# **OXFORDSHIRE COUNTY COUNCIL'S RESPONSE TO CONSULTATION ON THE FOLLOWING DEVELOPMENT PROPOSAL**

**Application no:** 16/01000/F

**Proposal:** Development of the Village Centre (south) comprising a Hotel and associated facilities (involving the partial demolition and the refurbishment and extension of Building 455 and its change of use); Bar/Brasserie (involving the partial demolition and refurbishment and extension of Building 457) and a Covered Market (canopy link between Buildings 455 and 457) with associated landscaping and car parking

**Location:** Building 455 And 457 Heyford Park Camp Road Upper Heyford

TYPICAL CAMP ROAD ADOPTABLE 'VILLAGE SQUARE' RAISED TABLE

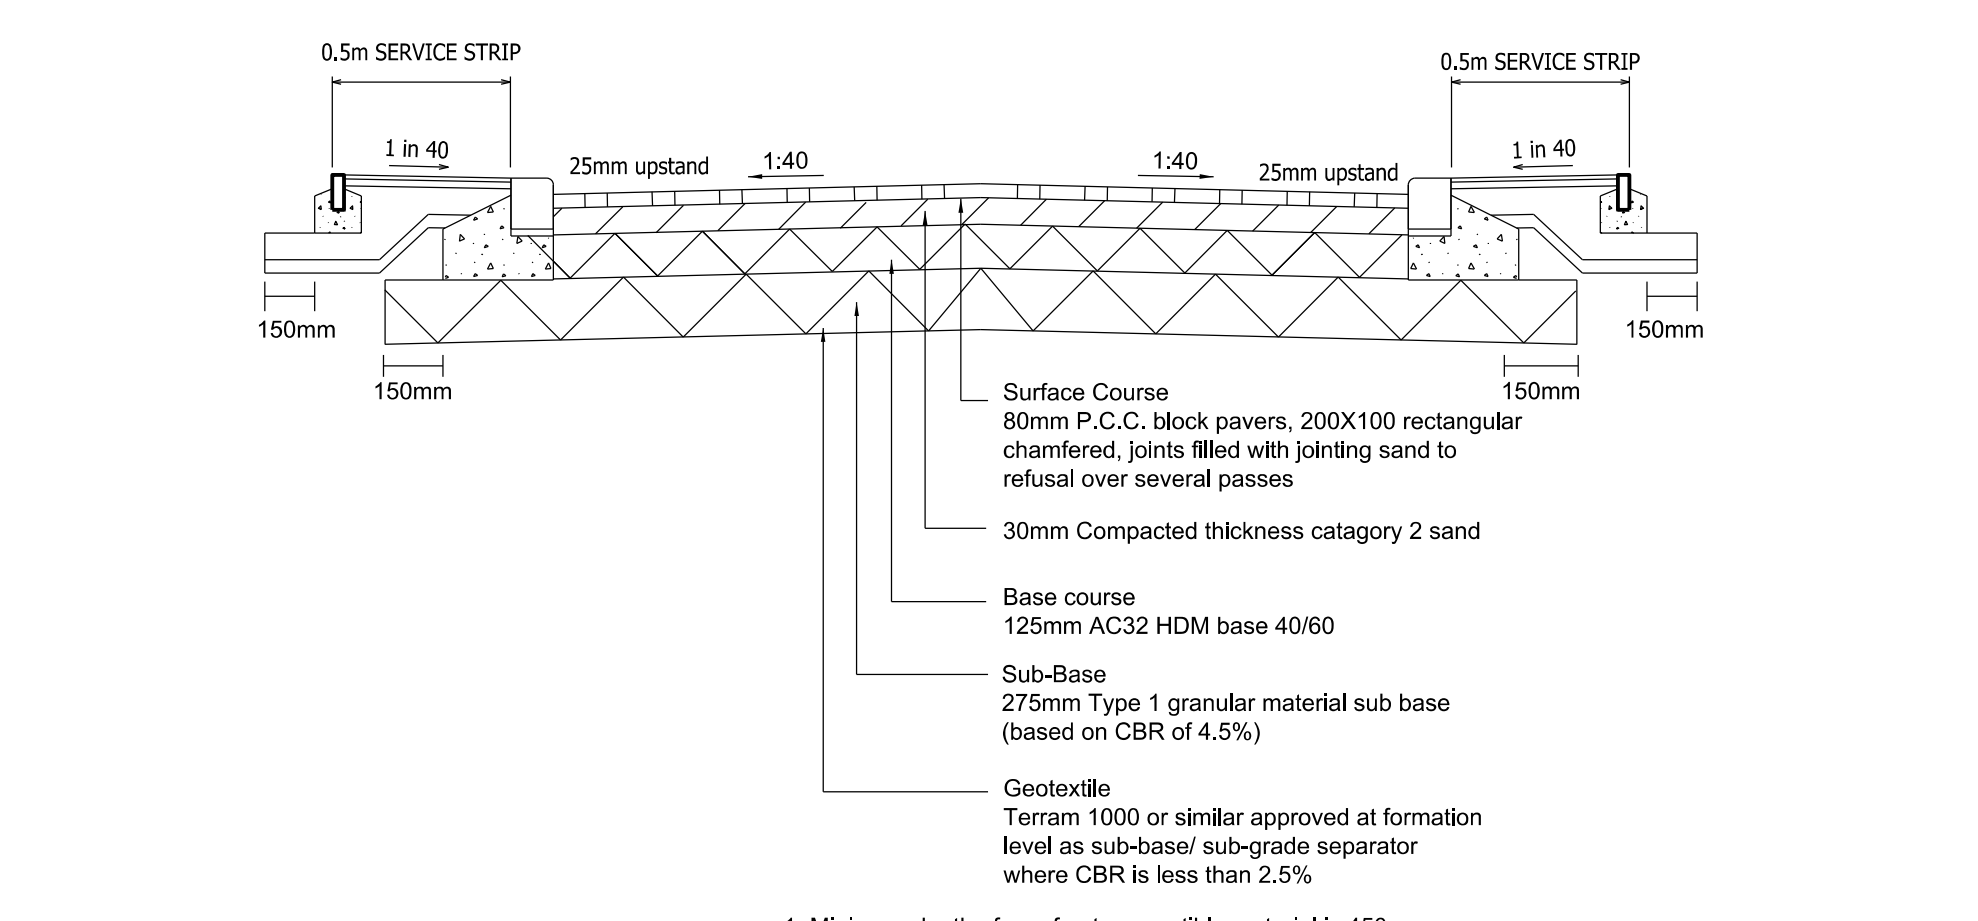
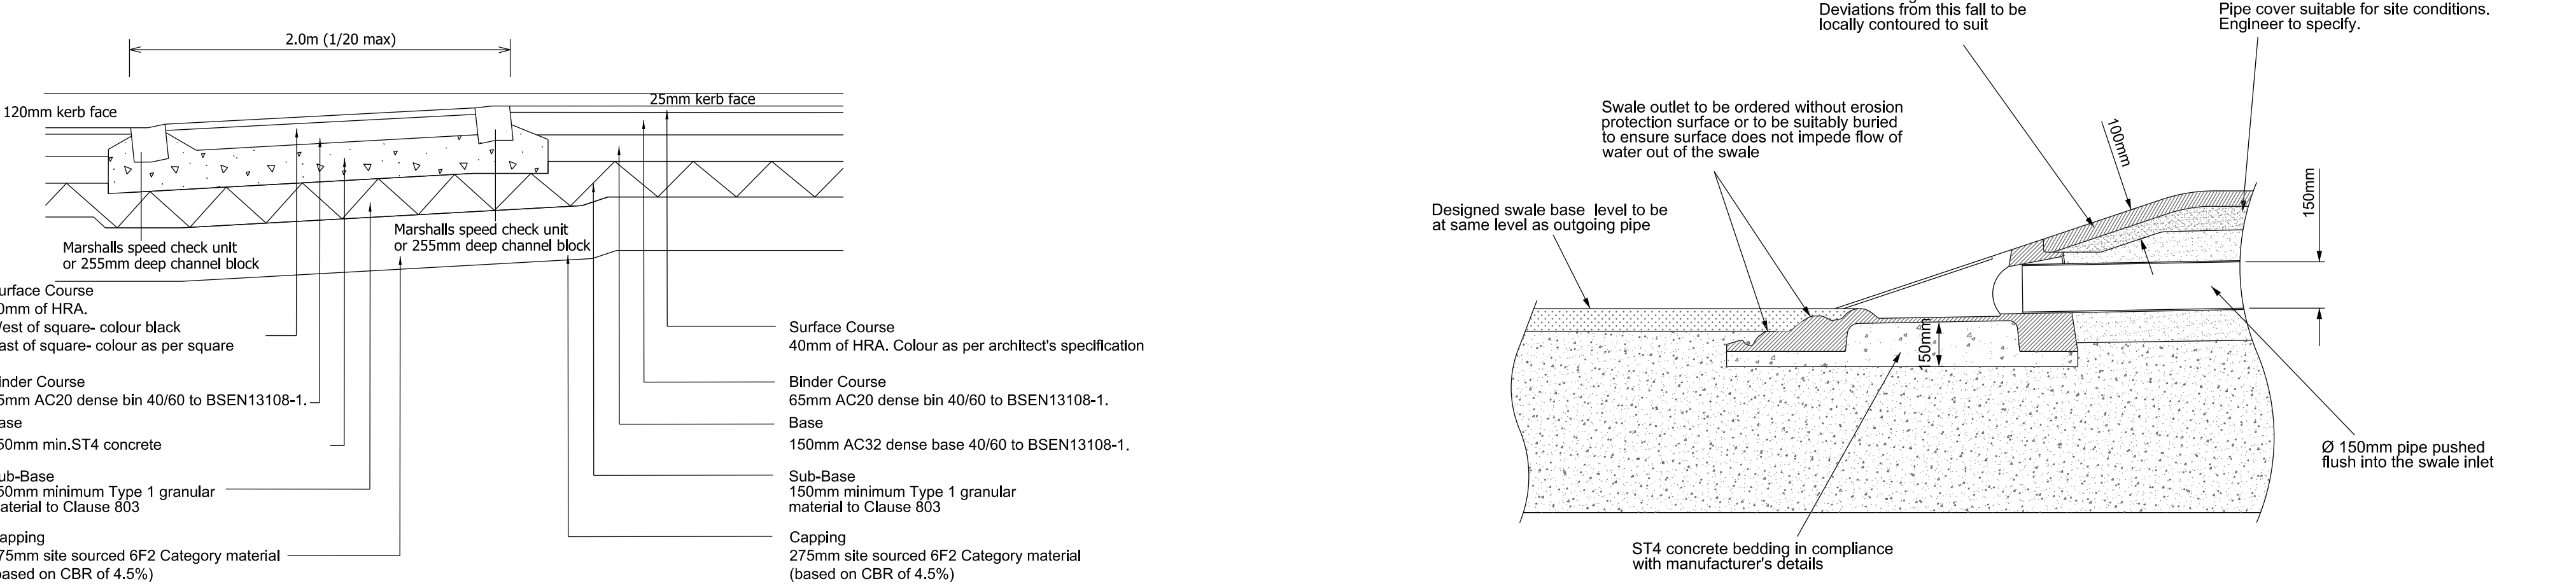
- Is it proposed to introduce a 70mm step/ramp in the footways surrounding the square to achieve the reduction in kerb upstand? This would not be acceptable particularly in a blank canvas situation. A reduction in kerb upstand would normally be achieved with a continuous kerb level and ramped raised table in the carriageway. It is not clear how it is proposed to level the Eastern edge of the square to achieve the transition from 50mm to 120mm upstand

- The raised tables constructed on Camp Road to date have taken a battering from heavy speeding vehicles. Blockwork isn't an ideal material for such a road, and particularly not so for the ramps.

BUS STOP KERBING DETAIL

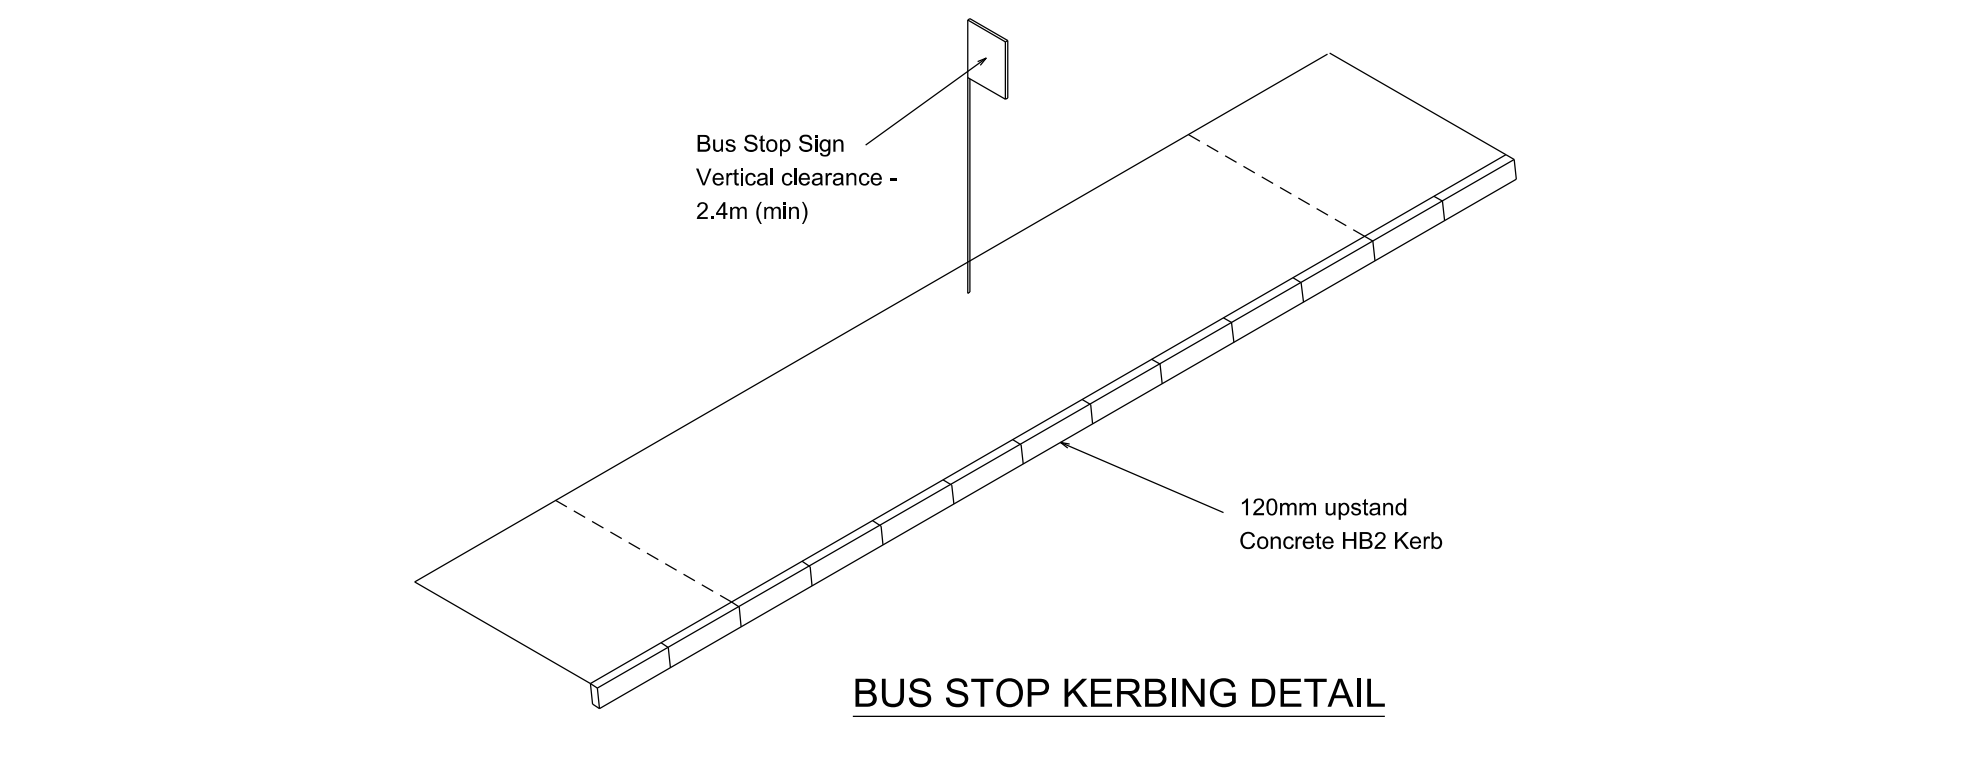
The bus laybys are not big enough for buses to pull up to the kerb properly. Also, the bus that has been used for tracking is too small. A 12m bus is required. In fact, laybys here for the buses are not really necessary and the scheme might be better without them. Buses are not expected to stop for long in the village centre.

- For maintenance reasons OCC would not accept a spray and chip surface treatment on the crossing due to the bus manoeuvres.
- For maintenance reasons OCC would prefer to see a black top finish to bus laybys. The proposed red brick paving will not stand up to the required manoeuvres.

LINEAR KERB DRAINAGE CHANNEL

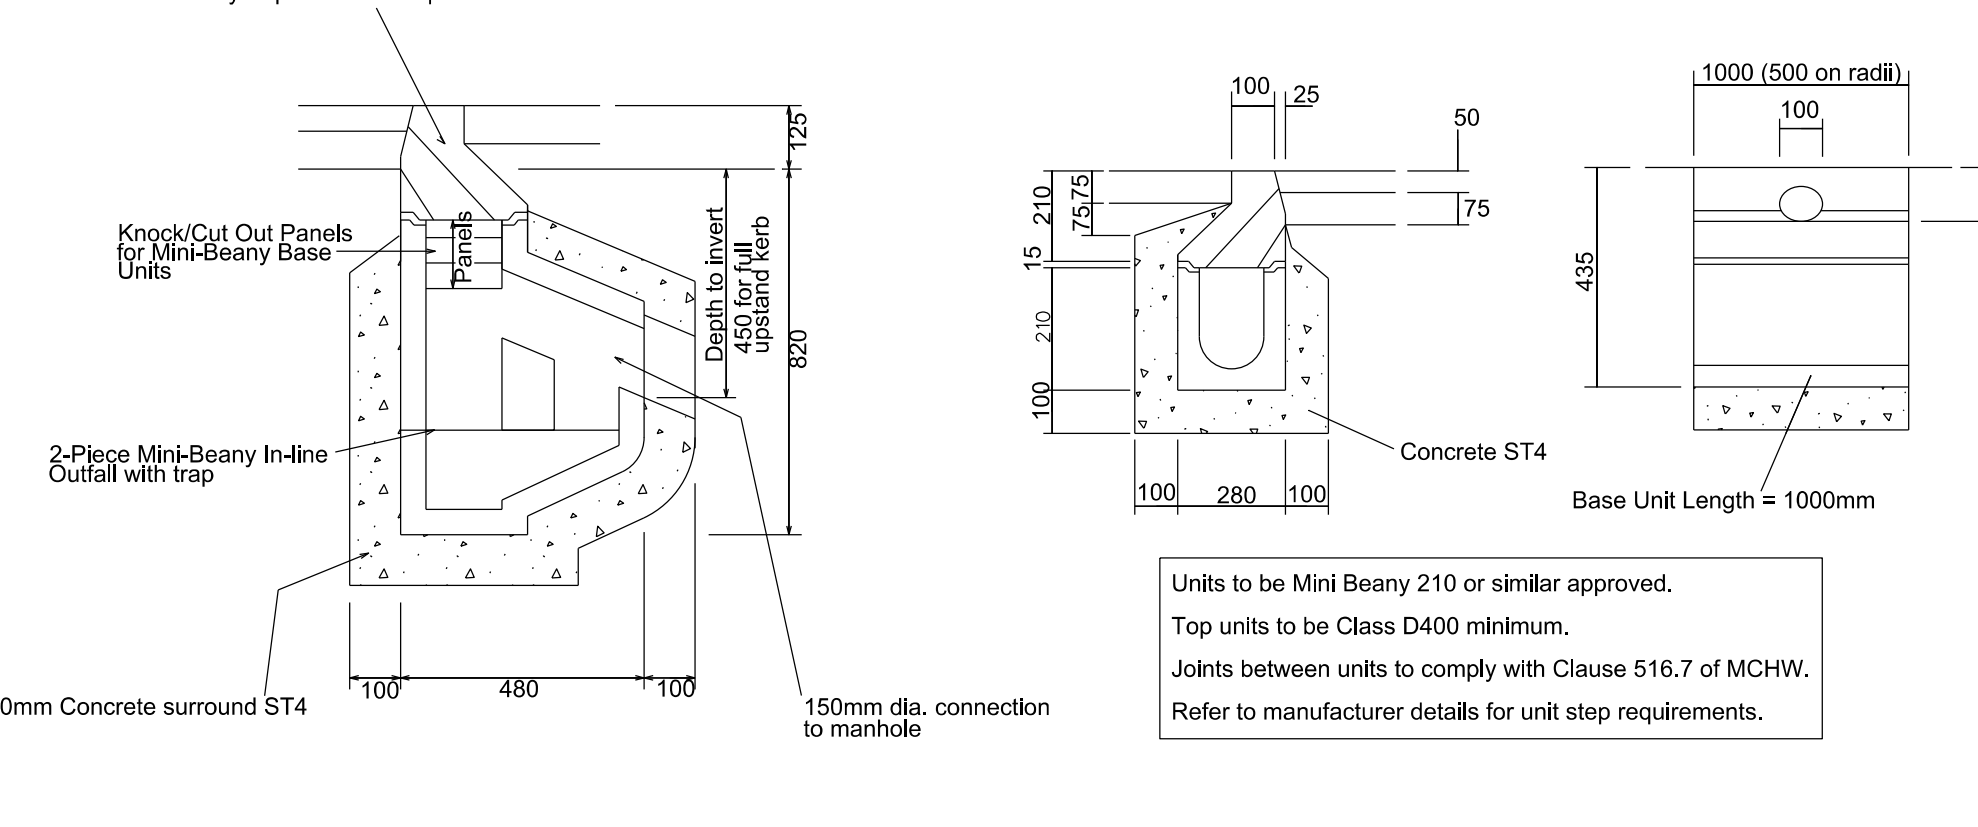
- For maintenance reasons OCC will not accept slot drains in adoptable areas. OCC would not wish to adopt the whole of the square, and private areas should not drain on to the highway.
